Application for Removal or Variation of a Condition following Grant of Planning Permission or Listed Building Consent

Erection of 1 no. semi-detached dwelling with associated parking and landscaping

34796/APP/2023/255

The application is for an S73 minor material amendment , with condition no.2 to be varied relating to that of the approved drawings.

PROPOSED ROOF PLAN
SCALE 1:100

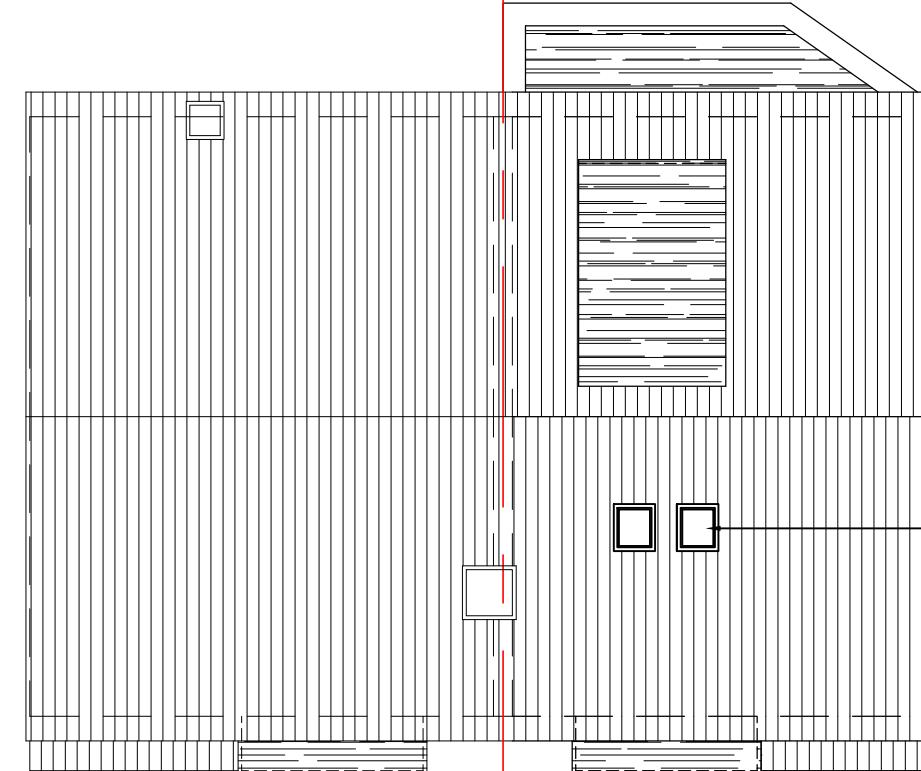
The approved drawings under the application 34796/APP/2023/255, do not show the roof windows to the front elevation and roof plan. 2 nos. of roof windows are required to comply current building regulations part O calculations. So the amended drawings for the revised roof plan and revised front elevation are submitted here in lieu of previously approved roof plan and front elevation.

Approval of the revised drawings in lieu of those previously approved under application 34796/APP/2023/255.
